PCU017075

24 November 2010

**Re: Metcash Distribution Centre Project (MP 10-0140) at Lots 2 & 3 DP 1127100
Brabham Drive, Eastern Creek .**

TITLE SITE PLAN - STAGE 5

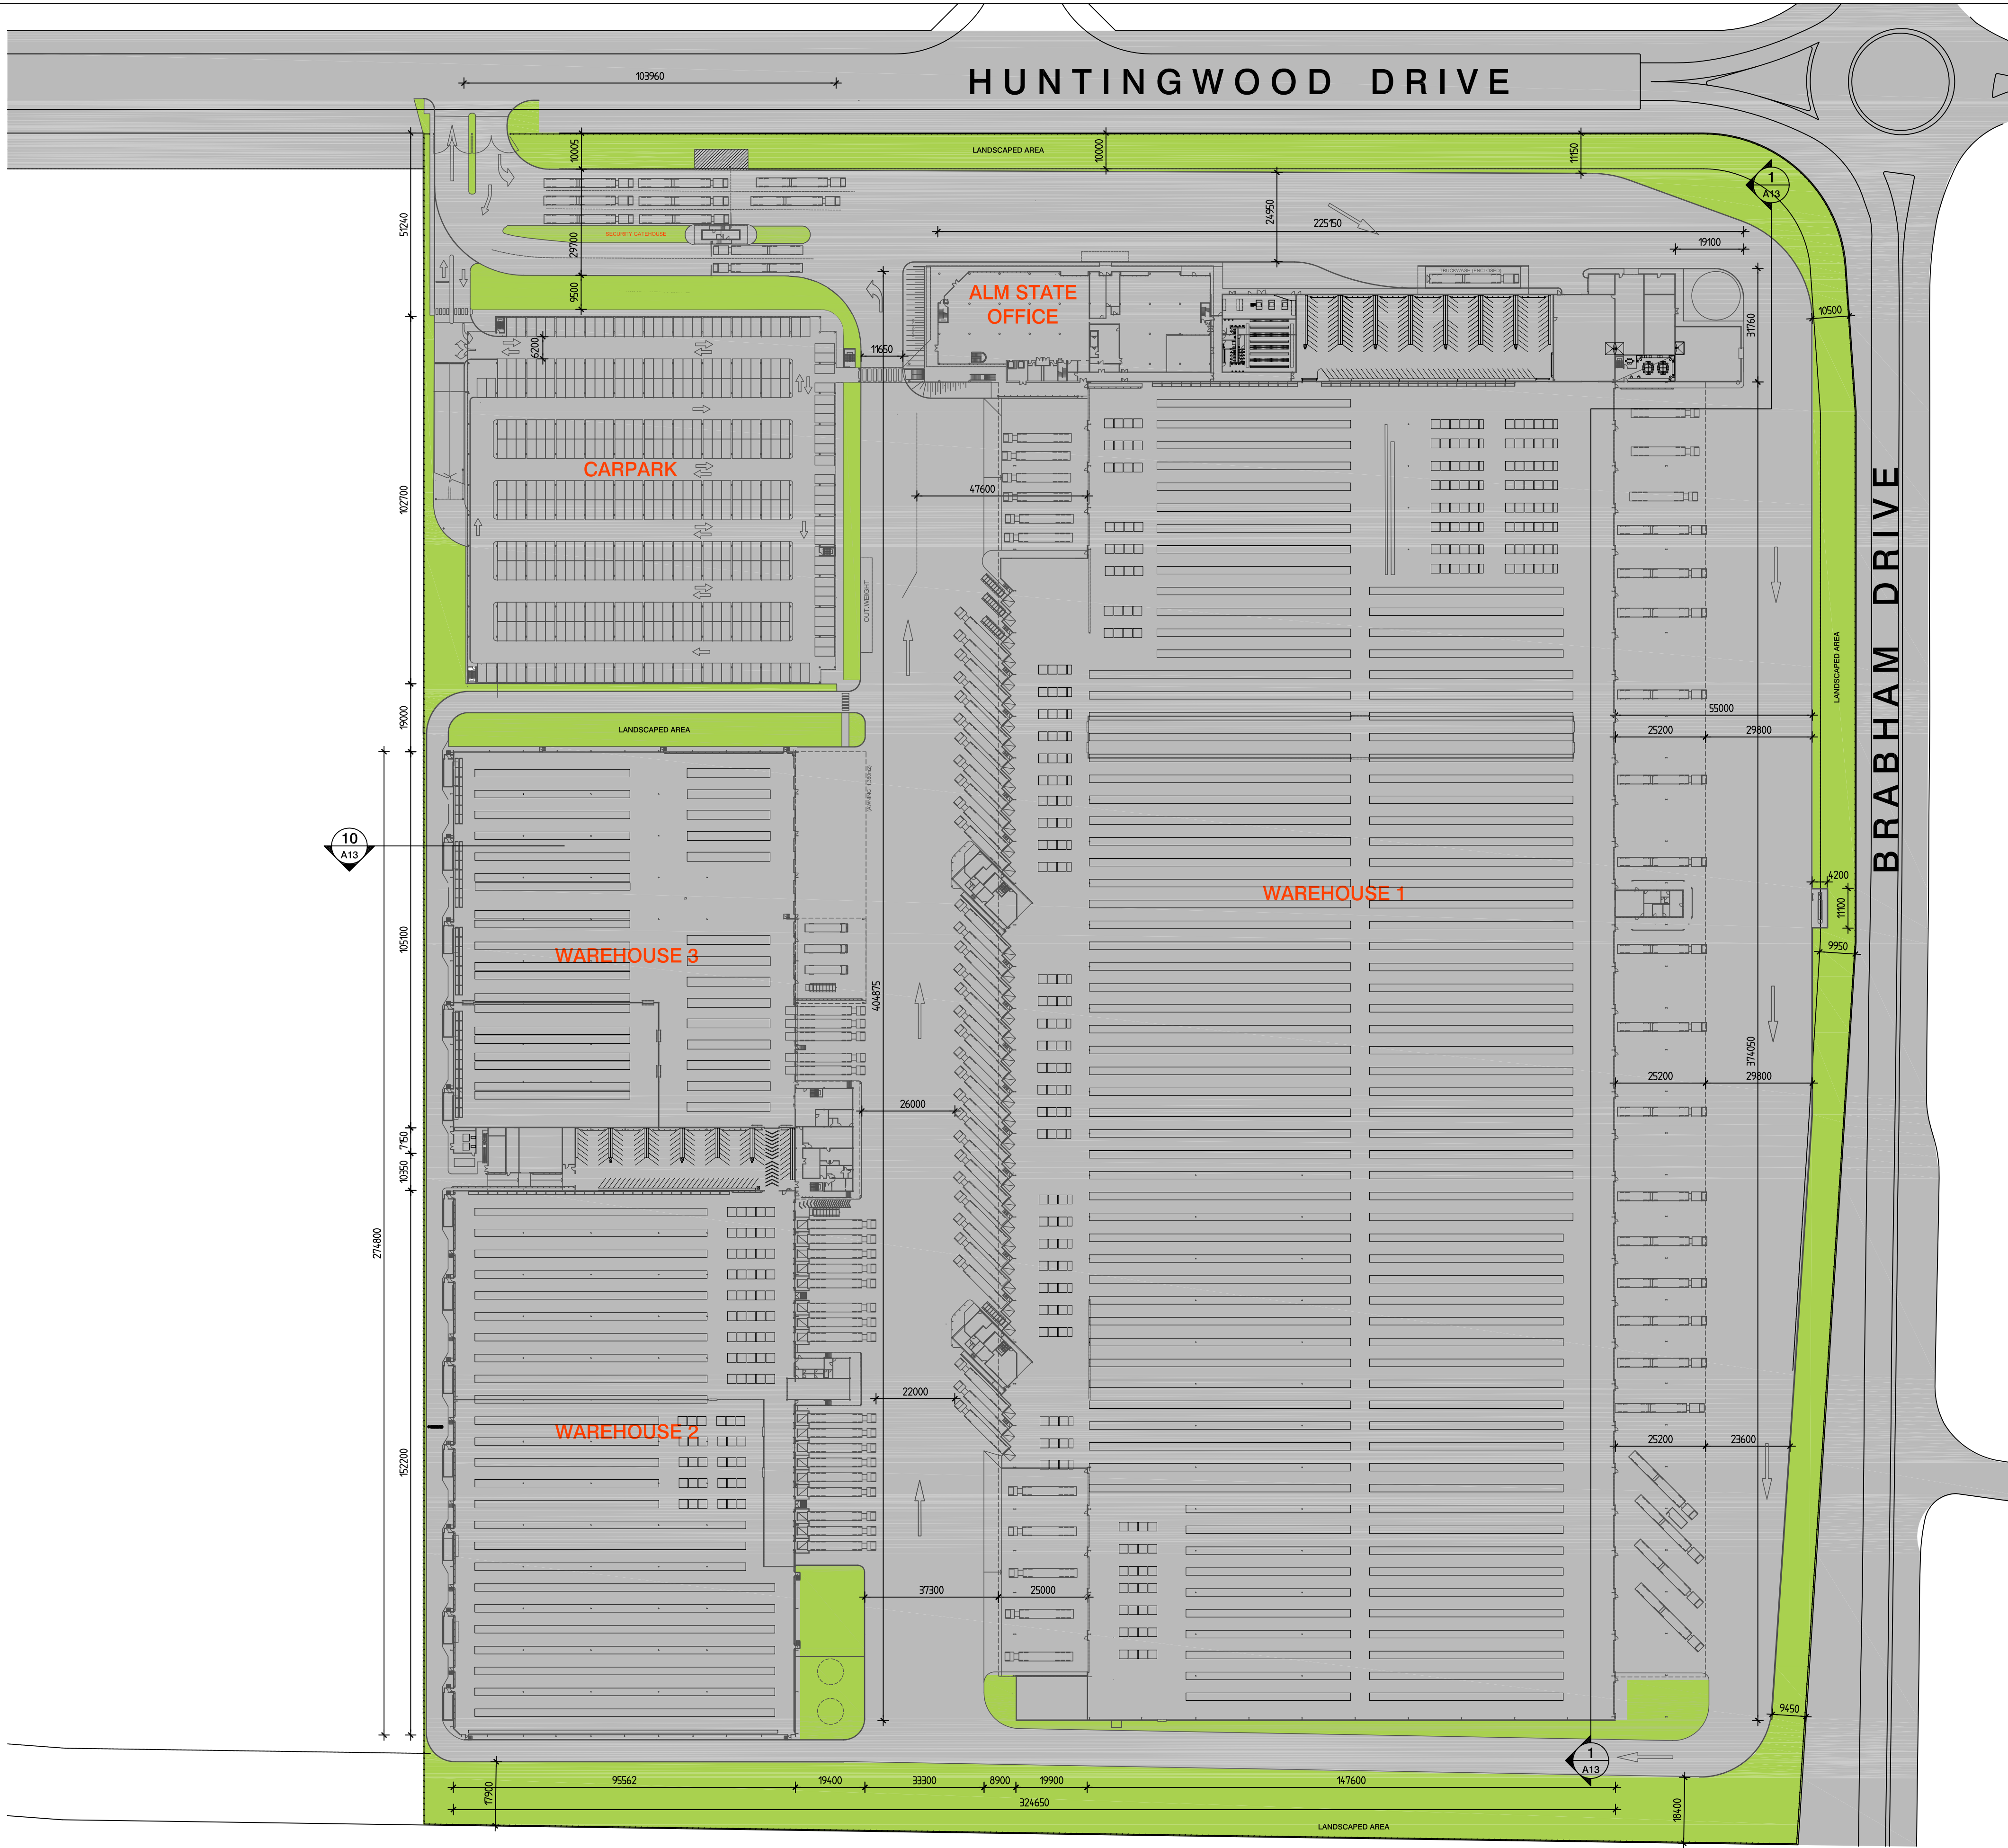
- (i) The proposal showed a shared driveway for both heavy and light vehicles to the western boundary of the site. The shared driveway is not supported as there is a conflict between trucks and cars near the car park entry ramp. It is our view that driveways must be separated to avoid conflicts between heavy and light vehicles. This could be achieved by providing truck access as part of the precinct plan roundabout between Lots 2, 3, 4 and 6 and retaining the western access point for cars only.

- (ii) It is noted with concern that the proposal suggested the deletion of the precinct plan roundabout between Lots 2, 3, 4 and 6 resulting from the removal of access road between Lots 2 and 3 without any consideration to the road safety at this location. Council does not support the deletion of this roundabout on the safety grounds as the removal of the roundabout would create a "T" intersection which requires some form of control as the predominant movement will be along the extension of Huntingwood Dr and the Great Western Highway via new roads north of the extension of Huntingwood Dr.
